Submission No.			003	
Organisation Name or Name of Submitter			Aidan Cyril Forde (Cordarragh, Brighton Road, Foxrock) - submitted by Magahy Broderick Associates Structural Civil & Environmental Engineers

Item No.	Section Ref.	Page No.	Observation Statement	TII Response
We write on behalf of our client Aidan Cyril Forde, Cordarragh, Brighton Road, Foxrock, Dublin 18 to make an submission/observation in relation to the Railway (Metrolink-Estuary to Charlemont via Dublin Airport) Order 2022				
1	Observation	1	TII wish to thank you for your submission. Responses where relevant are provided below in (3) and (4).	TII wish to thank you for your submission. Responses where relevant are provided below in (3) and (4).
2	Observation	2	<p>We have obtained some information from McCrae’s Consulting Engineers archives in relation to the foundations of the building and can confirm that secant piles (750-900mm diameter) were used around most of the perimeter of the building. The piles used were cast in situ concrete bored piles and were in the region of 8.5 to 9.5m deep. The basement slab level is c. 4m below the finished ground floor level, with the underside of the car lift pits a further 2m be

DRAWING NUMBER: ML1-JAI-BOR-ROUT-XX-DR-Y-02857

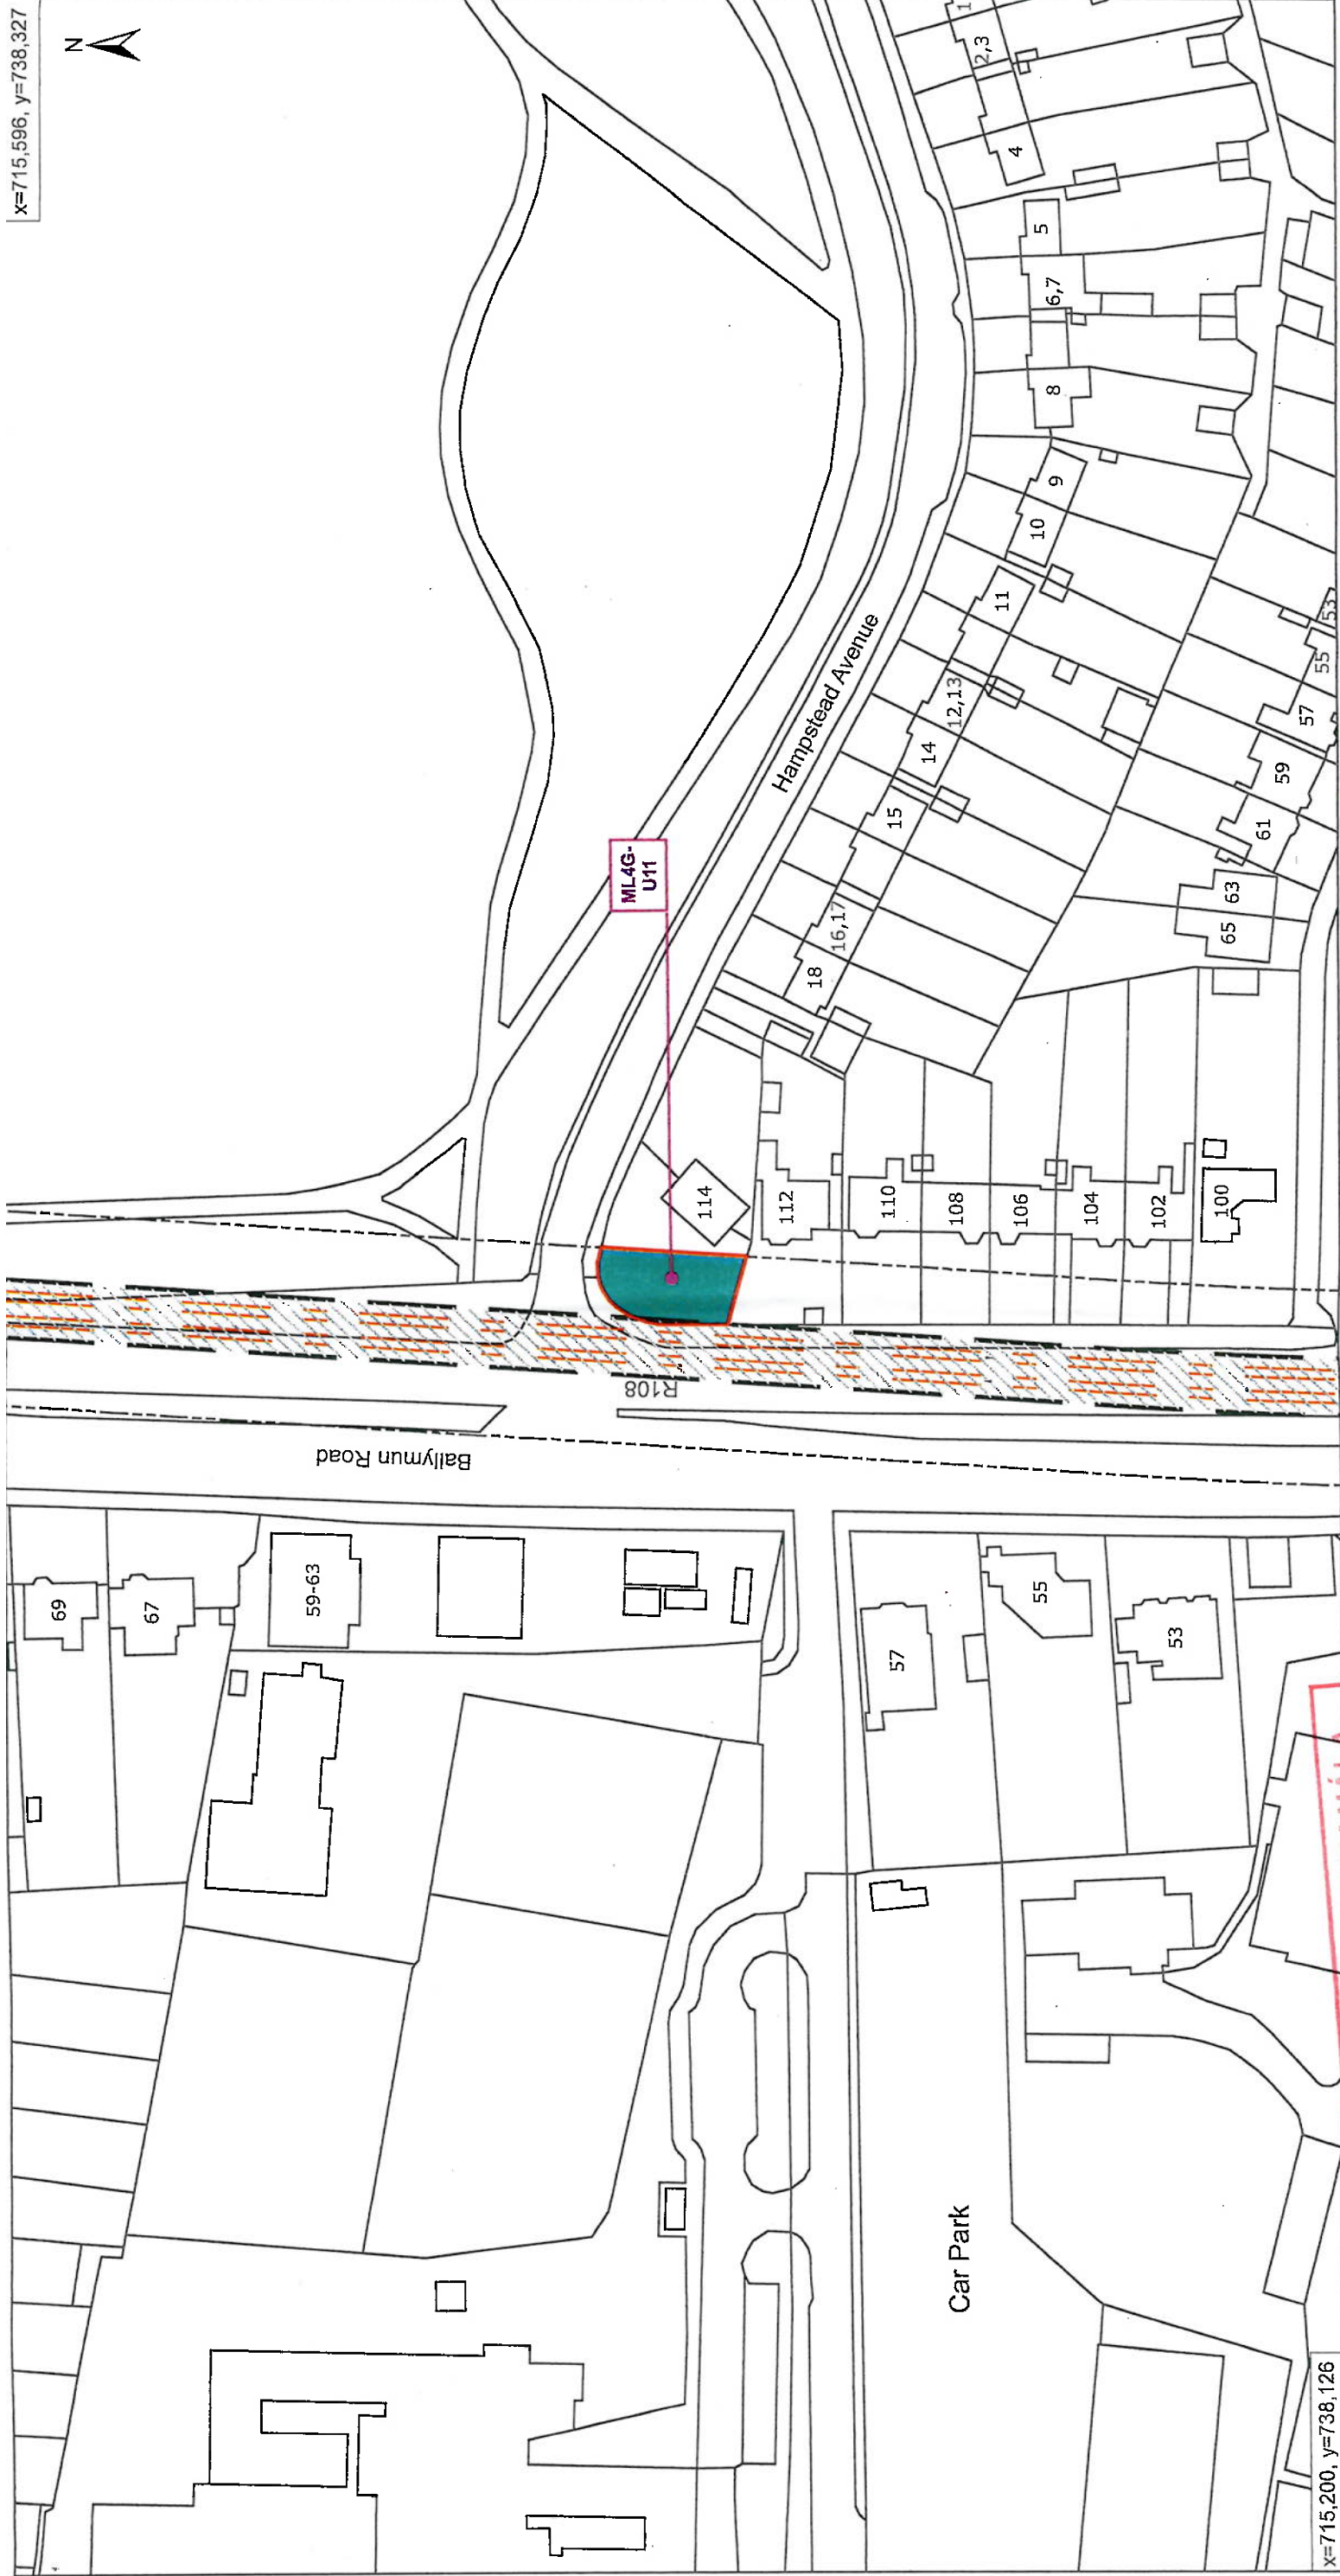
3	Observation	3	The piles are installed down to the level of the limestone bedrock and we have concerns that vibration from tunnelling could affect our clients foundations if the final chosen location of the tunnel is too close to the bedrock the piles are bearing onto.	<p>With regard to the proximity of your basement piles to the tunnels and the impacts of vibration on your structure, EIAR Chapter 14 Groundborne Noise and Vibration, Appendix 14.5 presents the predicted groundborne vibration levels during the construction phase of the project for 10/11 Leinster Street South:</p> <p>The predicted level of groundborne vibration during TBM passage is 0.248 ms-1.75 day and 0.208 ms-1.75 night, below the VDV (Vibration Dose Value is a parameter that combines the magnitude of vibration and the time for which it occurs) Threshold Level of 1.0 ms-1.75 day and 0.5 ms-1.75 night, resulting in a not significant impact on the building.</p> <p>It should also be noted that there is no other mechanical excavation nor blasting at this location, resulting in no impact on the building.</p> <p>With regard to settlement induced by the tunnelling operations your buildings have been assessed as being within the "negligible" damage category and hence no significant impacts are anticipated. This is as detailed in EIAR Appendix A5.17.</p> <p>The design includes for a limit of deviation which is required to allow for unforeseen obstructions and construction tolerances which may necessitate a change to the alignment. In the highly unlikely event that this were to occur, any resulting environmental impacts will comply with the limits set by the enforceable Railway Order.</p> <p>TII has carried out a comprehensive set of ground investigations in accordance with relevant guidelines and best practice. It has a high confidence that MetroLink can be constructed along the proposed alignment without requiring vertical or horizontal adjustment. However, in order to guard against rare and undetectable subterranean conditions that might interfere with construction, the Railway Order provides for limits of deviation (as have other railway authorisation since at least the 1840s). The impacts of potential changes within the Limits of Deviation are considered in the Wider Effects Report (Appendix A5.19).</p>
